**STATE SIGNIFICANT DEVELOPMENT
ASSESSMENT REPORT INCLUDING
RELEVANT SUPPORTING INFORMATION
AND ENVIRONMENTAL PLANNING
INSTRUMENTS**

Mixed Use Hotel Development

1 Alfred Street, Sydney

D/2016/1529 (SSD 8111)

2 LEVEL 03 - GRAND BALLROOM
SCALE1 : 400

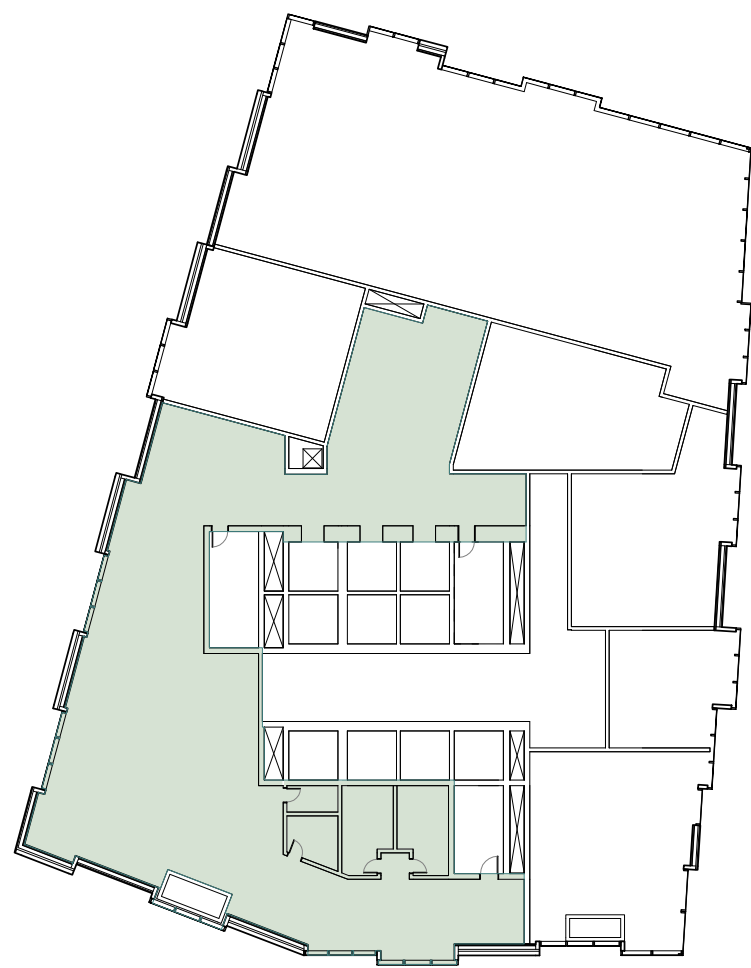
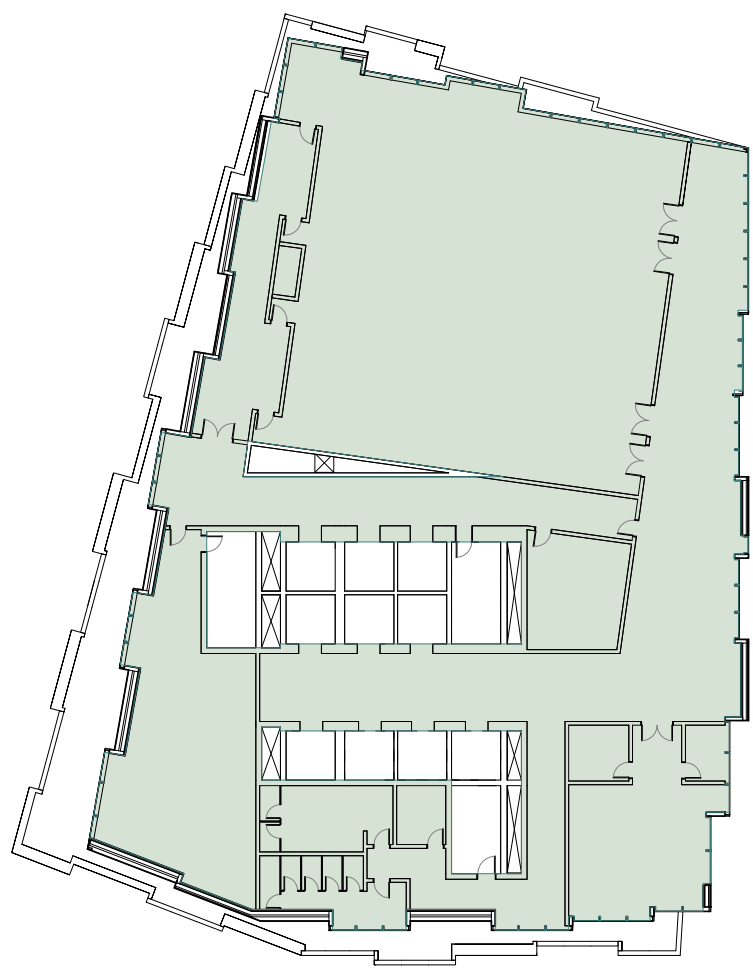
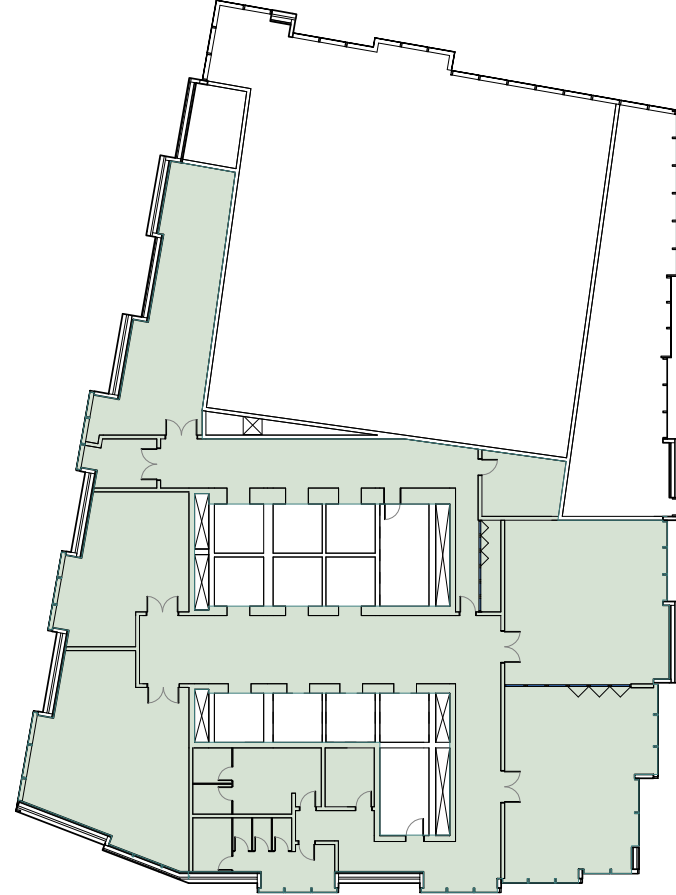
- The Grand Ballroom does not appear to provide adequate fire egress provisions. Egress requirements need to be investigated.
- The layouts of the Grand Ballroom pre-function spaces need refinement for effective circulation and operations.
